67 Landcroft Road

Design, Access &
Planning Statement

21st April 2021

DEVELOPMENT MANAGEMENT – PREAPPLICATION RESPONSE – COVER SHEET

DRAWING  
 PROPOSED  
 ROOM AREAS

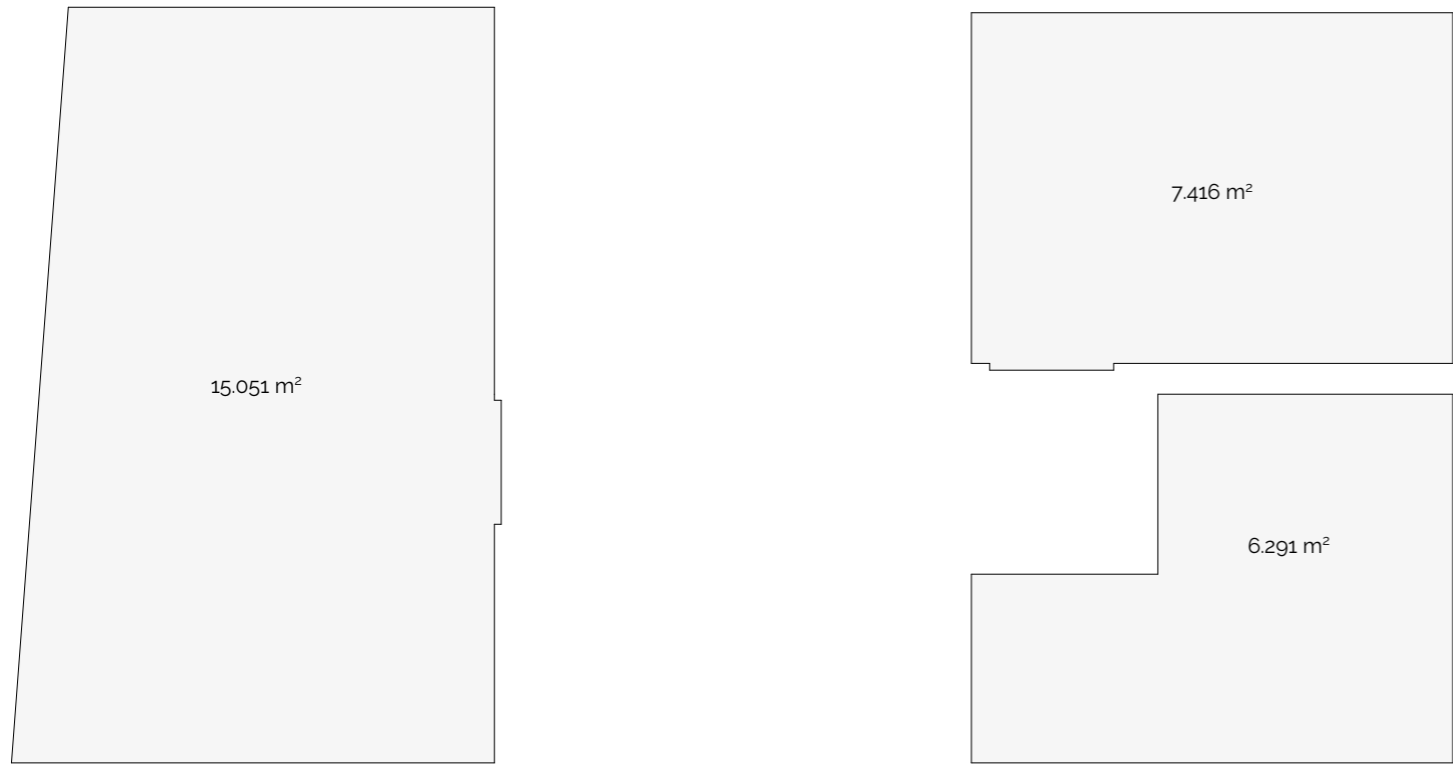
The proposed site is a two-storey, 2x double bedroom dwellinghouse. The required Gross Internal Area according to the 2015 update to the Residential Design Standards is 79 sqm. As stated, in the Design & Access statement, the unit is currently 76.24 sqm and therefore the would fail to comply with the Residential Design Standards.

Room	Essential GIA (sqm)	Proposed GIA (sqm)	Complies?
Living/ Dining	17	16	No
Kitchen	7	7.3	Yes
Bathroom	3.5	3.5	Yes
Bedroom 1	12	16	Yes
Bedroom 2	12	15.5	Yes

In terms of individual space standards, the living/dining room falls short of the required space by 1 sqm. Otherwise, all the other rooms meet the required standards. However, it is unclear where built in storage is located which should be a total of 2.5sqm. This means the site still has a total of 3.5sqm unaccounted for in space standards as well as being 2.76sqm short of the required GIA of 79 sqm.

Changes to the interior layouts now mean the property is a 2 bedroom, 3 person property.

Southwark's Residential Design Standards SPD (2011) sets out minimum space standards. 2 bedroom 3 person 2 storey properties should be at least 70m² the proposed development is 74.1m².

Storage should be 2m². The proposed allows 2.38m² storage space.

Minimum room areas for properties dictate, double bedrooms should be 12m². The double bedroom is sized at 15.1m². Single bedrooms should be 7m², the bedroom included is 7.4m².

Combined kitchen, dining and living spaces should be 27m² in a 2 bedroom property. The development allows 27.4m².

DRAWING
 PROPOSED
 SITE & GARDEN AREA PLAN

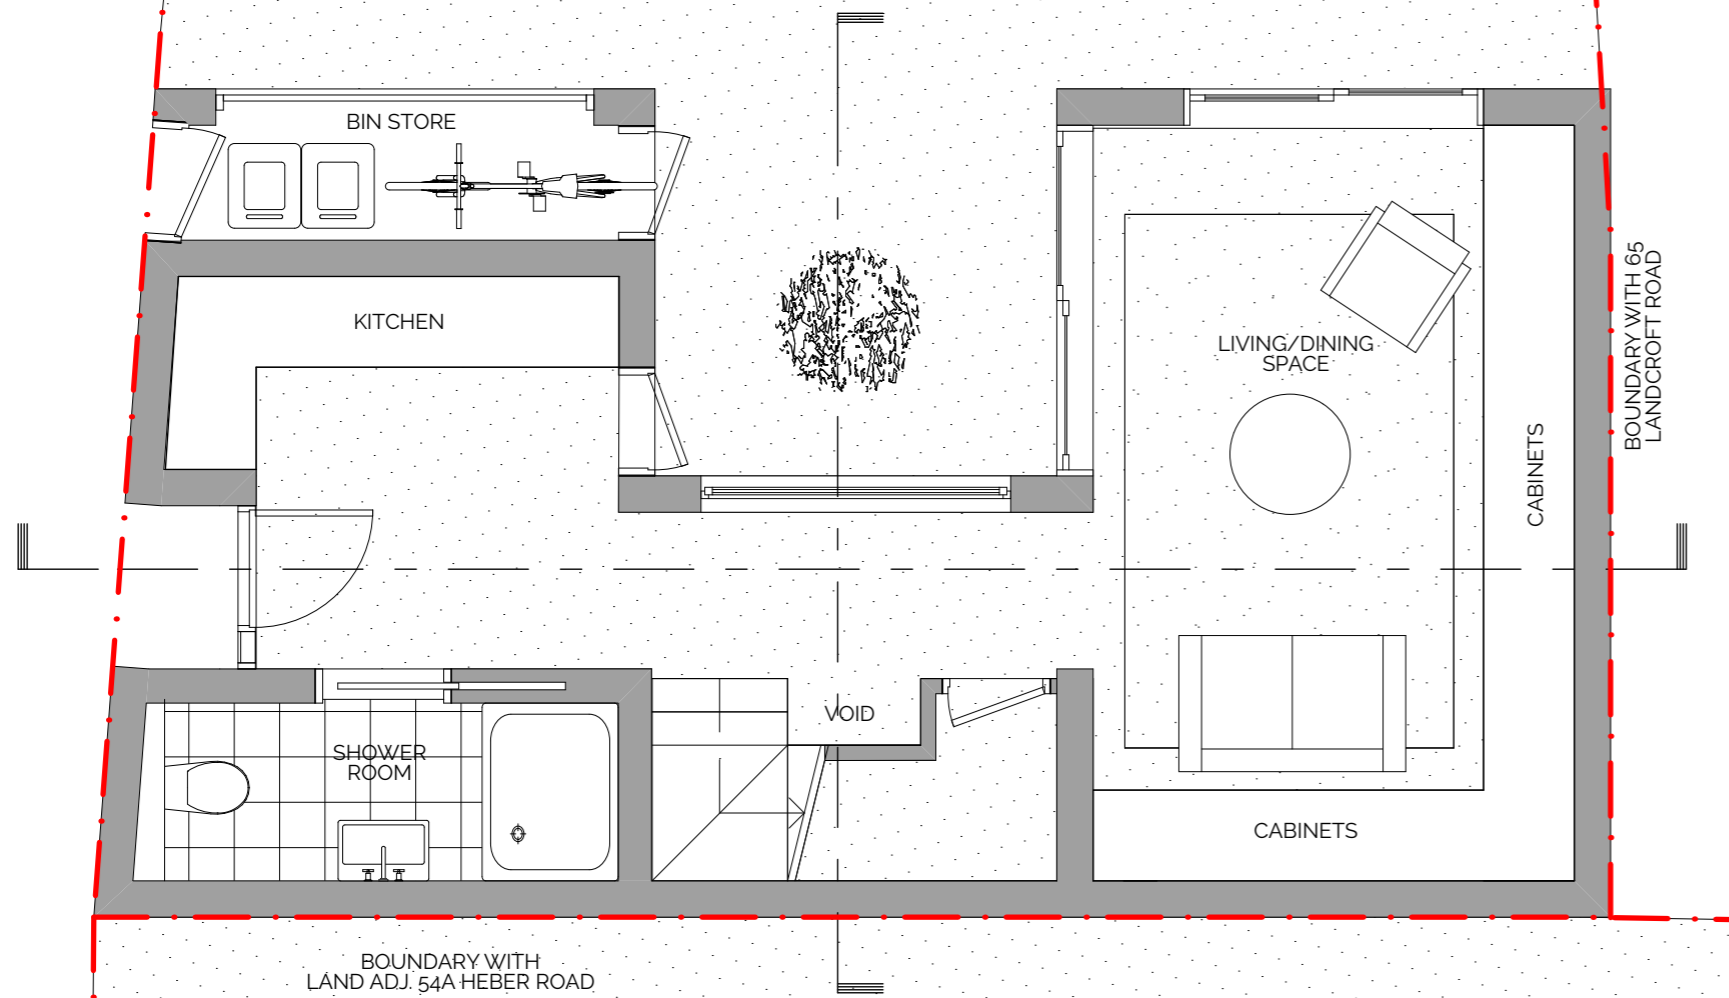
Moreover, the officer does not consider that the spatial constraints of this site are an acceptable reason for failure to comply with space standards, as the host dwelling benefits from a large garden space. Furthermore, for new dwellings a garden should have a size of 50 sqm in accordance with the Residential Design Standards. In this respect, the council will agree to exercising a level of discretion given the constraints of the application site's garden. However, the total area of the garden is proposed at around 6.6 sqm, which would not be acceptable, and a minimum of 25 sqm is expected.

In order for this application to be acceptable, a balance will need to be struck between loss of host property's amenity space and space standards for the proposal site. At present, there is clear scope for an increase in amenity space for the proposed dwelling.

The garden areas for the existing and proposed properties are clearly defined. The new garden is 27.9m², above the suggested 25m².

27.9m² of private outdoor garden space is allocated in response to pre-application advise this is to be a minimum of 25m².
